From: [REDACTED]
Sent: 18 March 2026 10:28
To: [REDACTED]
Subject: RE: Drainage condition Highcroft, Painter Wood, Whalley Old Road, Billington, Lancashire BB7 9JD

Drainage condition Highcroft, Painter Wood, Whalley Old Road, Billington, Lancashire BB7 9JD

Planning application 3/2024/1022

PROPOSED DRAINAGE PLAN

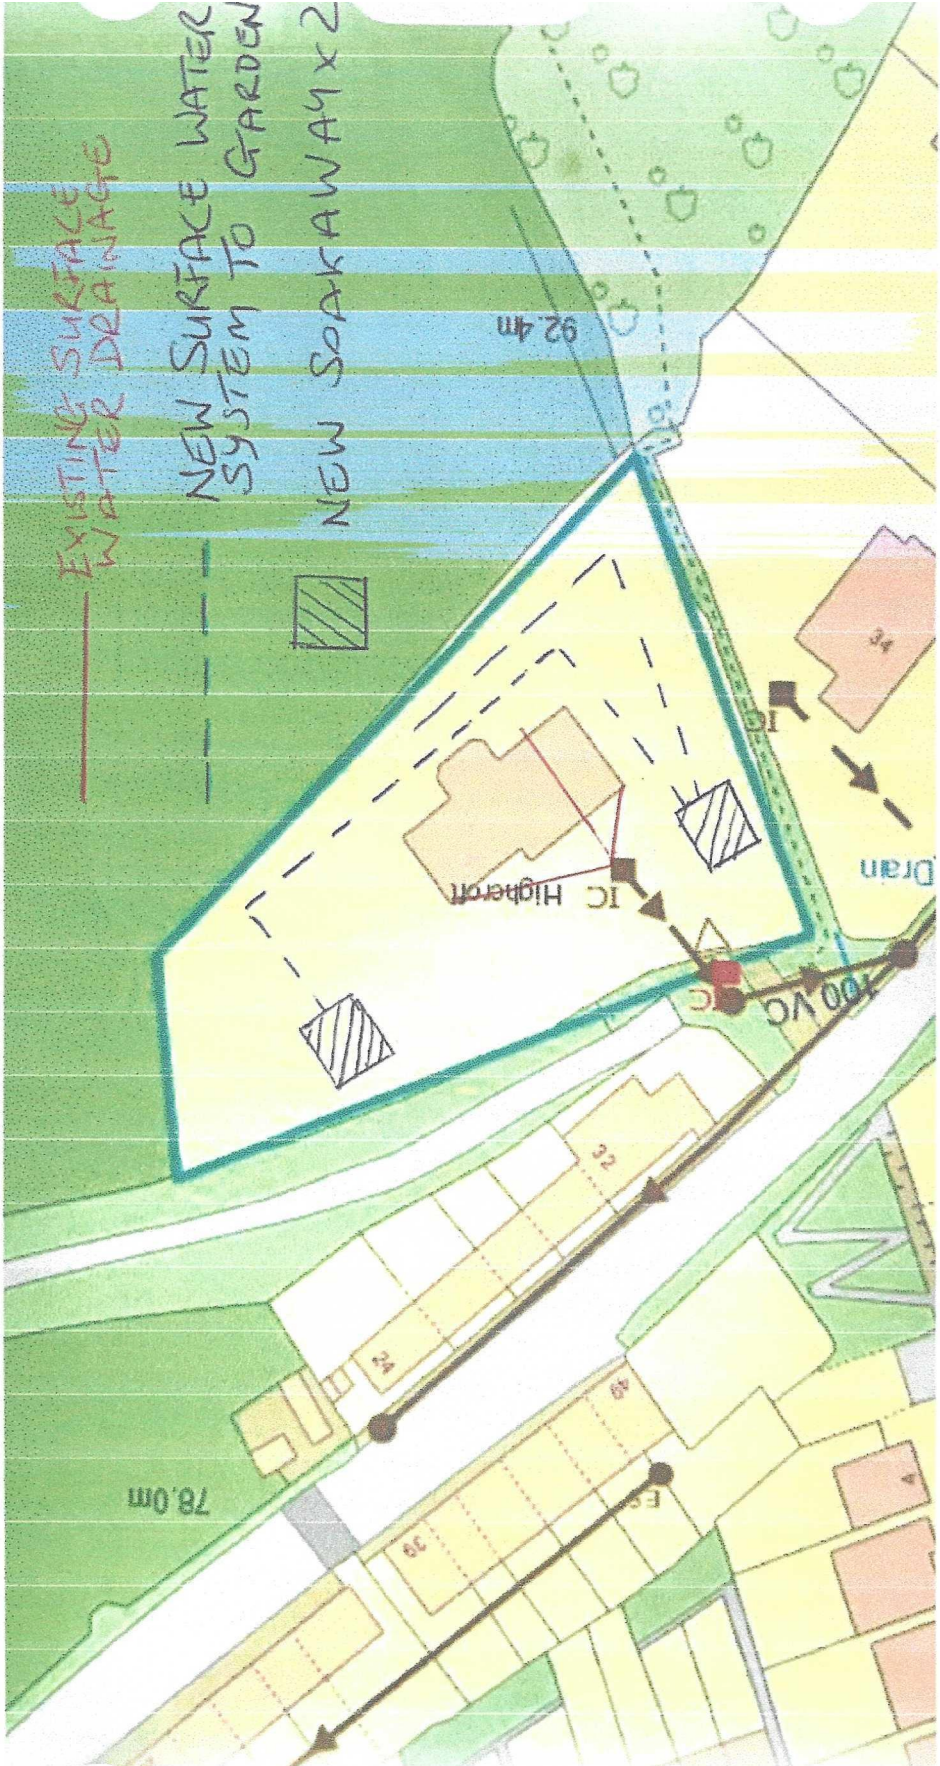
From what I can see, the original application was refused due to no plan being submitted and only FW being present.

During our phone conversation you made it clear that UU would not permit any additional surface water drainage from the garden area and where a French drain is proposed at the back of the house and where the land slopes upwards away from it.

In the light of your comments, I've attached a plan to show that any water from this would not connect into UU infrastructure but would go to two soakaways located in the garden.

However, looking at the two soakaways I believe this will be accepted now.
